ATTACHMENT 1
Director-General's Requirements
Section 75F of the *Environmental Planning and Assessment Act 1979*

Additional Information Required

2 SUN STUDY - DECEMBER 12:00 PROPOSED AND EXISTING
DA-61 Scale 1:500

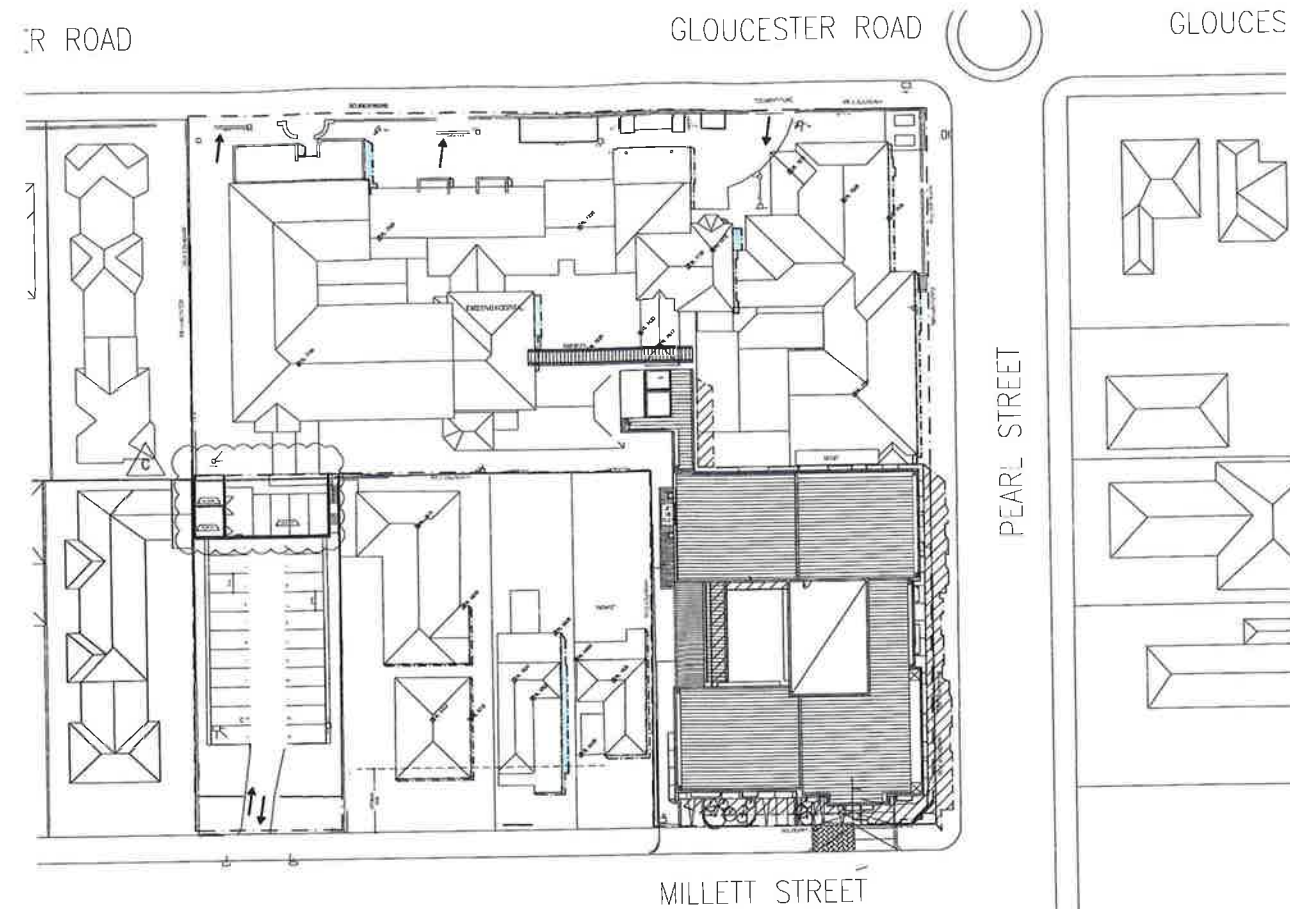
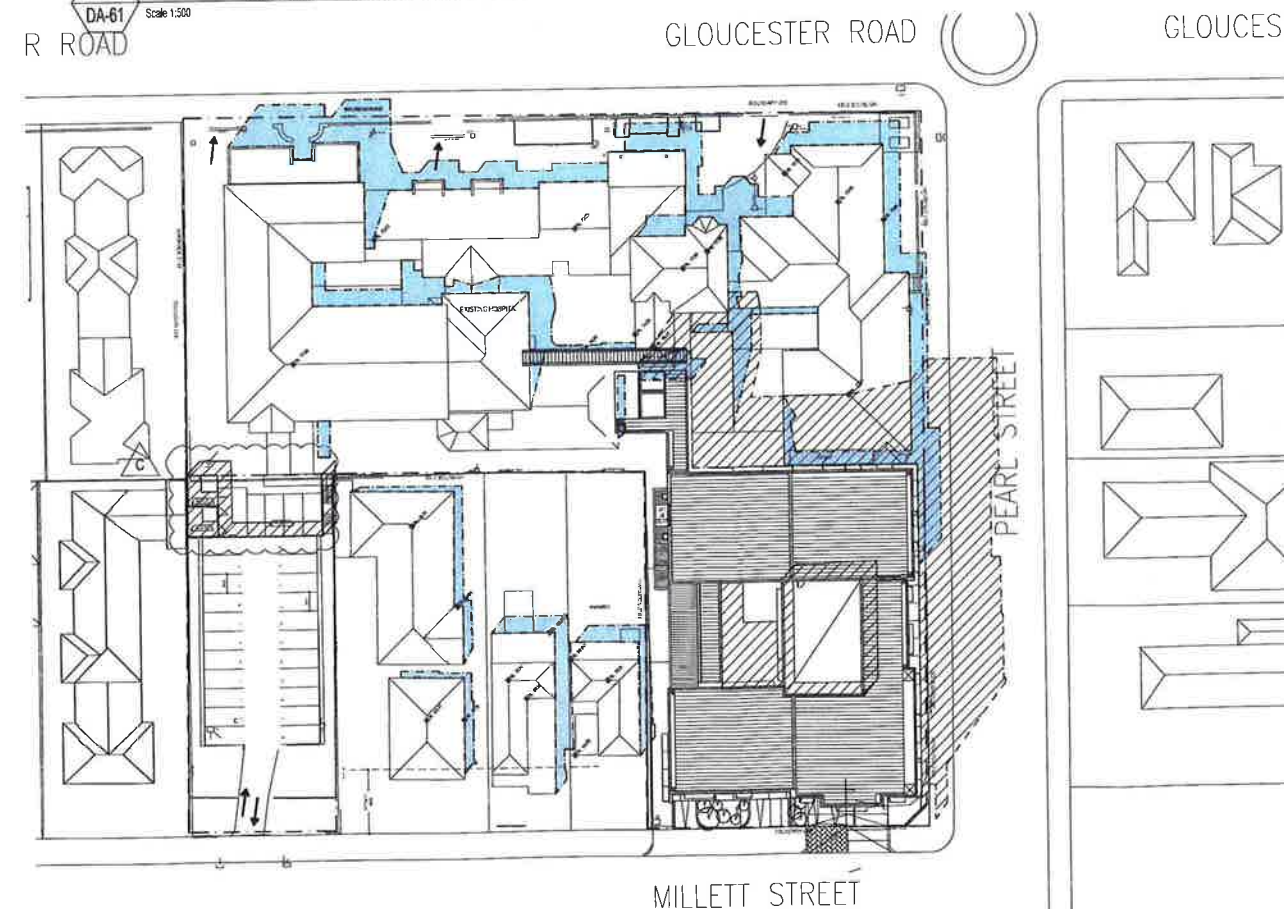
Environmental and residential amenity	Shadow diagrams - Shadow diagrams depict a different carpark arrangement to that shown on the architectural plans for 12 Millett St. Please rectify and show at a larger scale any new shadows cast on 10 Millett St (please also note the other comments in relation to this part of the proposed development) Overlooking of adjacent properties - Provide more information about the potential for overlooking of 14 and 10 Millett St from the proposed carpark deck at 12 Millett St and options for addressing any overlooking, including any proposed measures (such as screens, or louvers) to address them (including any shadow impacts) - Amend the building design to include privacy barriers such as louvers or screens that prevent overlooking of 6, 6A and 10 Millett Street from the windows of the new development but still allow distant views - Provide a north-west elevation of the building that shows the windows and any other openings, ventilation, exhausts or the like below level two of the proposed new building. Landscaping - Amend the carpark design of 12 Millett St to include shade trees in accordance with <i>Hurstville DCP1 Clause 3.1.2.2 (1) Landscaping</i>
